From: David Cairns [REDACTED]
Sent: 21 August 2017 08:44
To: David Easton
Subject: Fw: A/44/17/OUT at Land west of Brook Lane and South of A259

Subject: A/44/17/OUT at Land west of Brook Lane and South of A259

MASTER PLAN

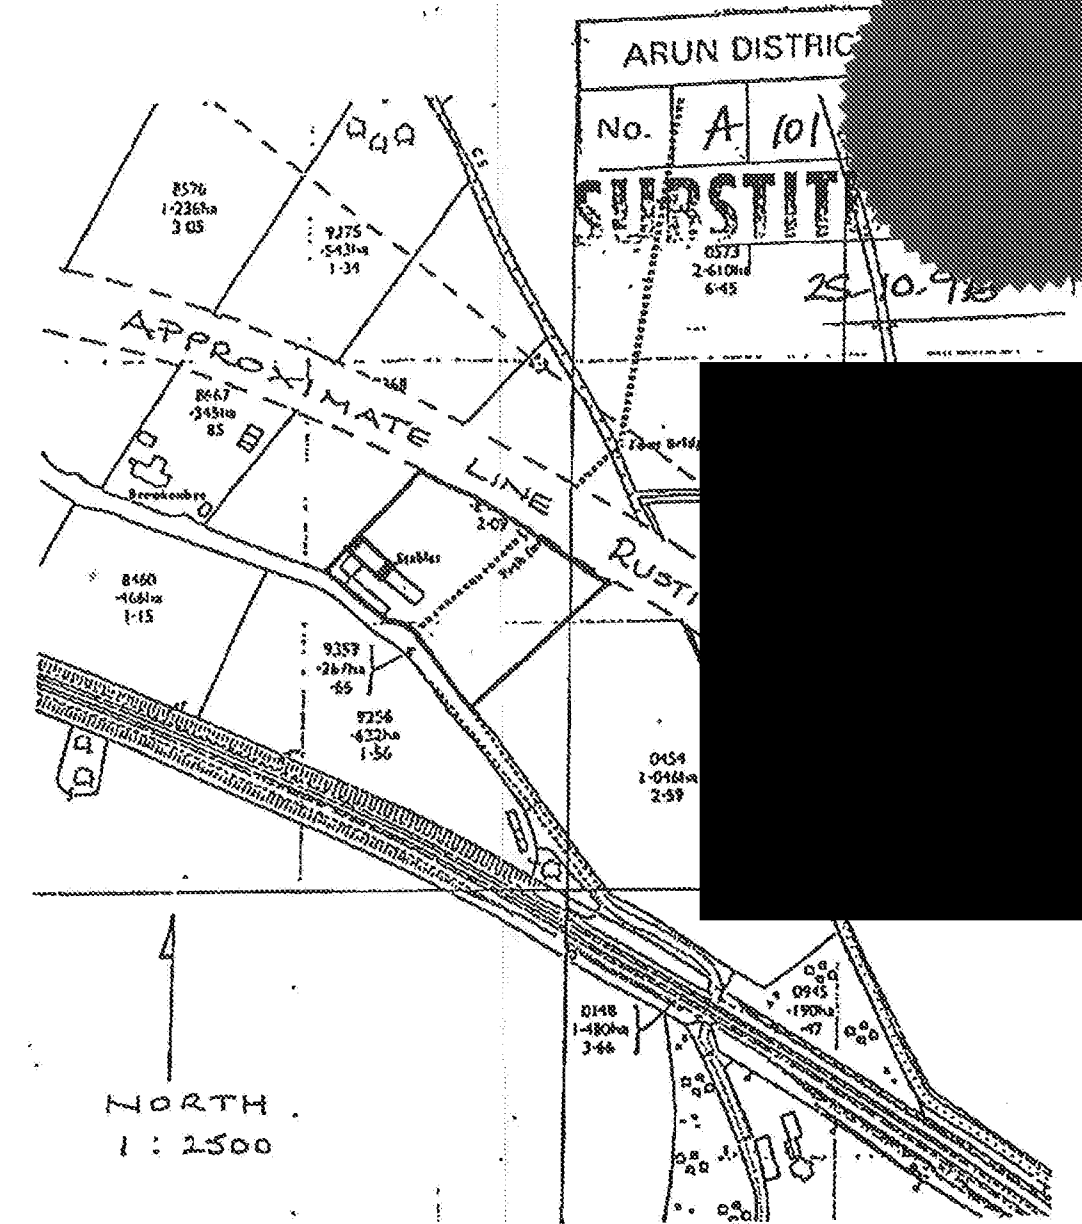
1. The proposed footbridge across the railway line. Where will the southern exit be ?. The map is unclear as to whether its exit is in Brookside trading estate or Penfold lane.

3. On the Indicative design plan 1709-07C the map shows the kick about space situated to the east of the Allotments as the "Allotment Gardens" Could you clarify please as there is no PROW (as I understand it) from the junction of the northern tip of Penfold lane, the allotments entrance and the potential exit of the proposed footbridge. There is however a man made short cut which extends through heavily built up Nettles and brambles through to the kick about space which forms part of Parklands.
